STATE OF NORTH CAROLINA DEPARTMENT OF TRANSPORTATION

Addendum No. 1

RE: Contract ID C202707 WBS # 5C.092131, 5CR.20921.30 Wake County 6 Sections of Secondary Roads

CURVE IMPROVEMENTS ON SR 1152 (HOLLY SPRINGS RD), SOUTH OF SR 1379 (PENNY RD)		
DIVISION 05 WAKE COUNTY		
REVISIONS	BY	DATE
SCALE: 1"=100' DATE: 3/15/2010		PREPARED BY: CAH REVIEWED BY: BJU
N.C. DEPARTMENT of TRANSPORTATION DIVISION of HIGHWAYS DIVISION FIVE DESIGN UNIT		REVIEWED BY:

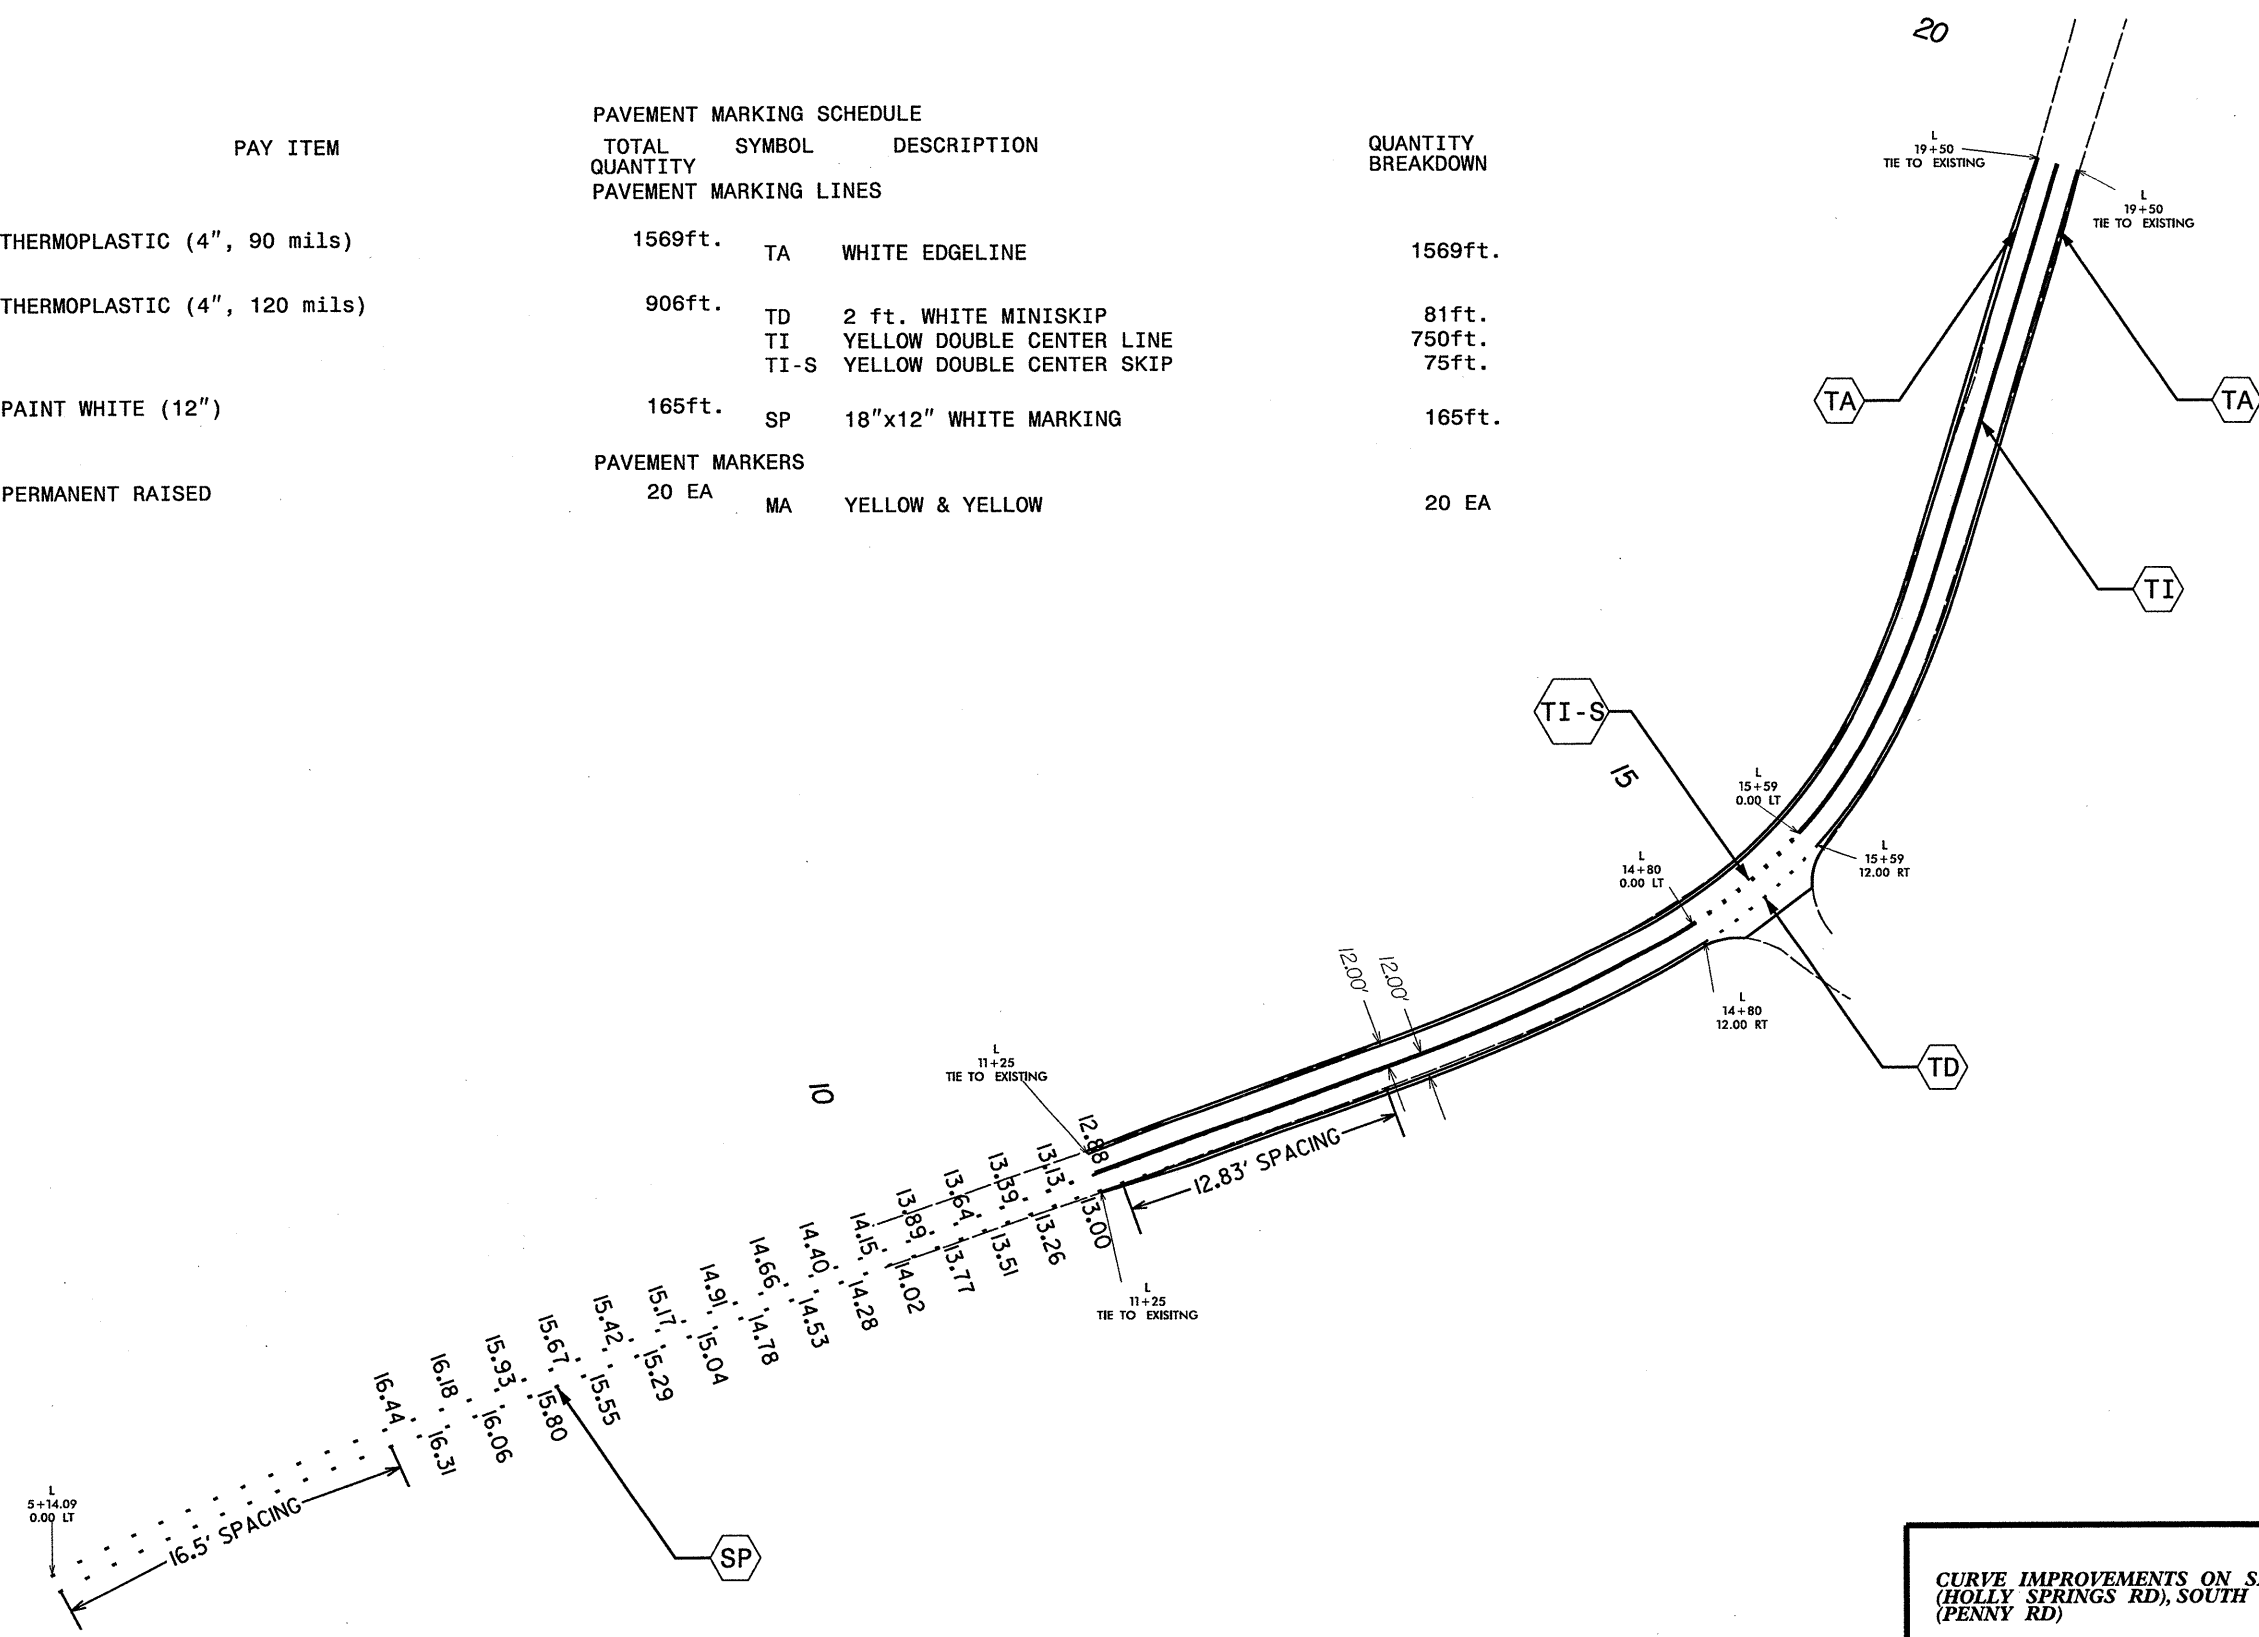
New Sheet No. PM-1 has been added to show the pavement marking plan for Map #7. Please staple new Sheet No. PM-1 after Sheet No. TCP-2 in your plans.
